Rezoning Transportation Analysis

Petition Number: #2021-198

General Location Identifier: Tax ID 18712322

Date	Description
12-23-21	First Review (WB)
11-23-22	Second Review (IW)

REZONING PETITION 2021-198

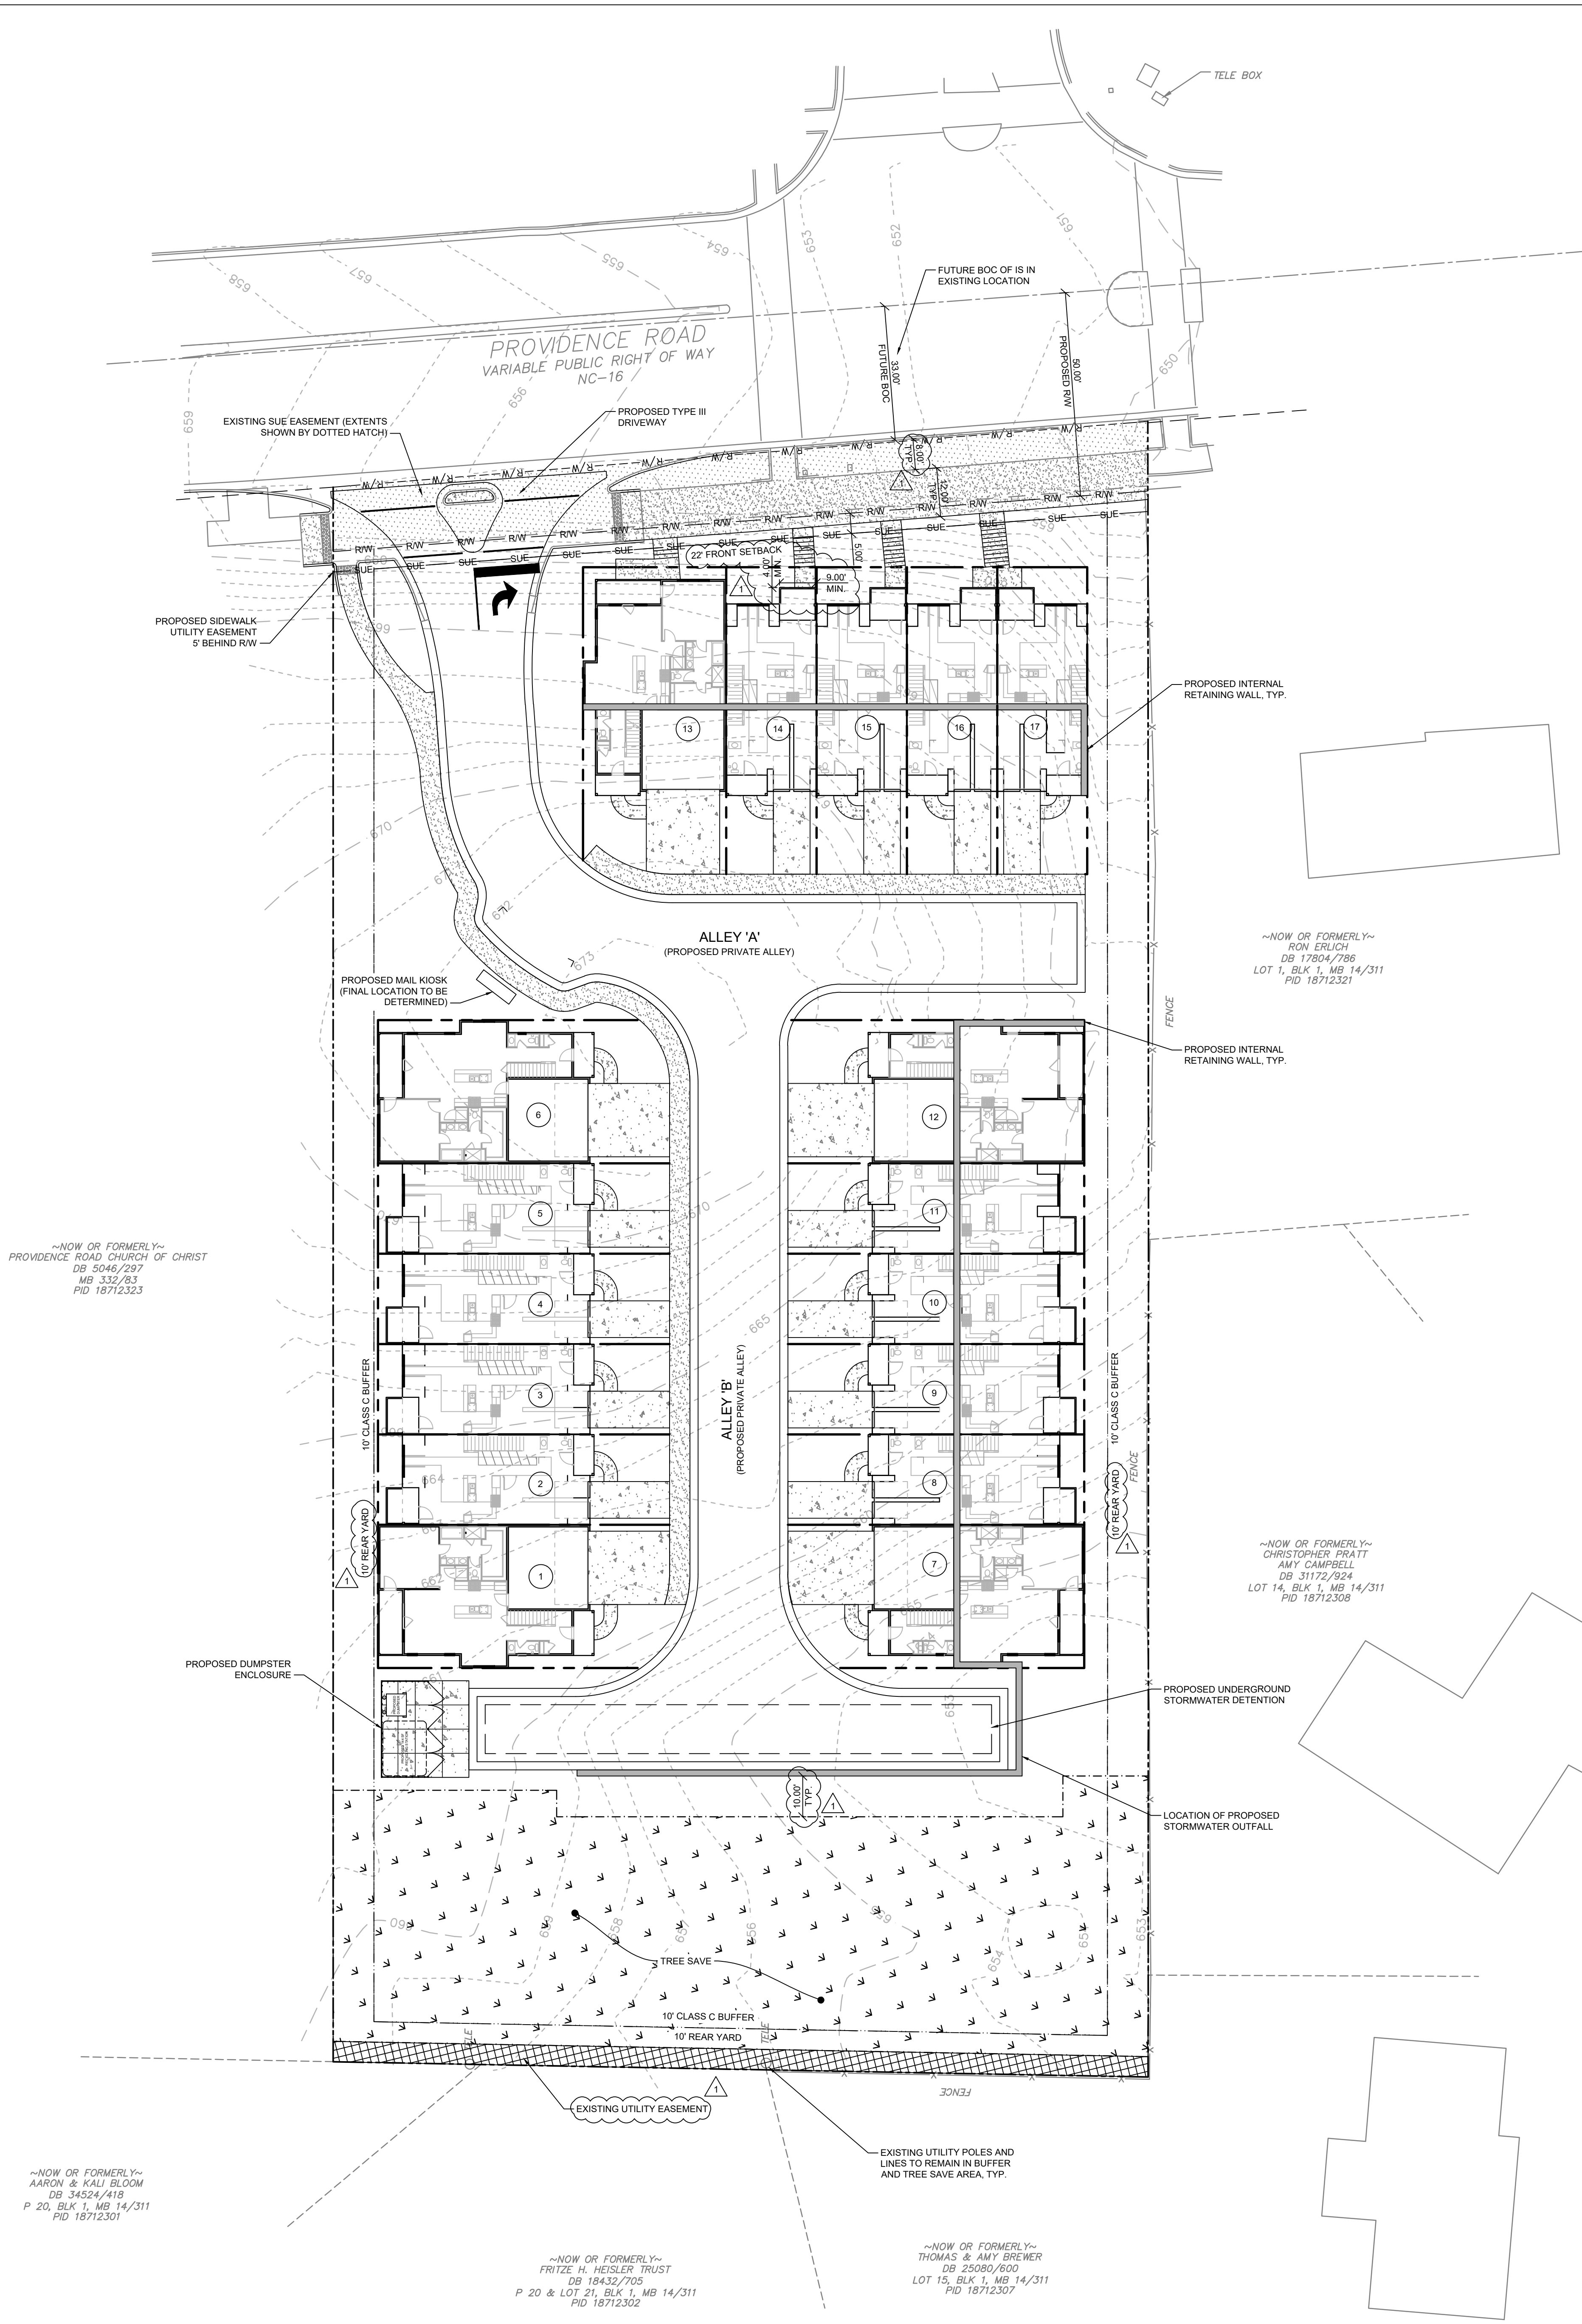
Label and dimension the existing and future curb and gutter from the centerline for each road on the site plan.

4. **Outstanding Comment from 12-23-21** Revise site plan and conditional notes to commit to dedicate 50-foot right-of-way from the Providence Road centerline. The site plan shall label and dimension the right-of-way from the road centerline. (refer to Note 6. figure)

5. **Outstanding Comment from 12-23-2021** Site plan and conditional notes revisions are needed to commit to construct bicycle facilities by installing a 12' multi-use path with an 8' planting strip to meet the City Charlotte BIKE Policy.
6. **Outstanding Comment from 12-23-2021** Revise site plan and conditional notes to commit to dedicate 5-foot sidewalk utility easement measured from the proposed right-of-way. CDOT requests that no steps be located within the SUE as the future sidewalk will be constructed therein. The site plan shall label and dimension the SUE from the proposed right-of-way.

7. **Outstanding Comment from 12-23-2021** Revise site plan to identify the location and container type for waste collection. Maneuvering not permitted in right-of-way or setback. Site plan design must accommodate ingress/egress maneuvering path of design vehicles.
8. **New Comment Based on 11-04-22 site plan:** The relocated driveway now creates a conflict with access to building. Revise and update site plan so that ramp leading to driveway access does not conflict with access to building.
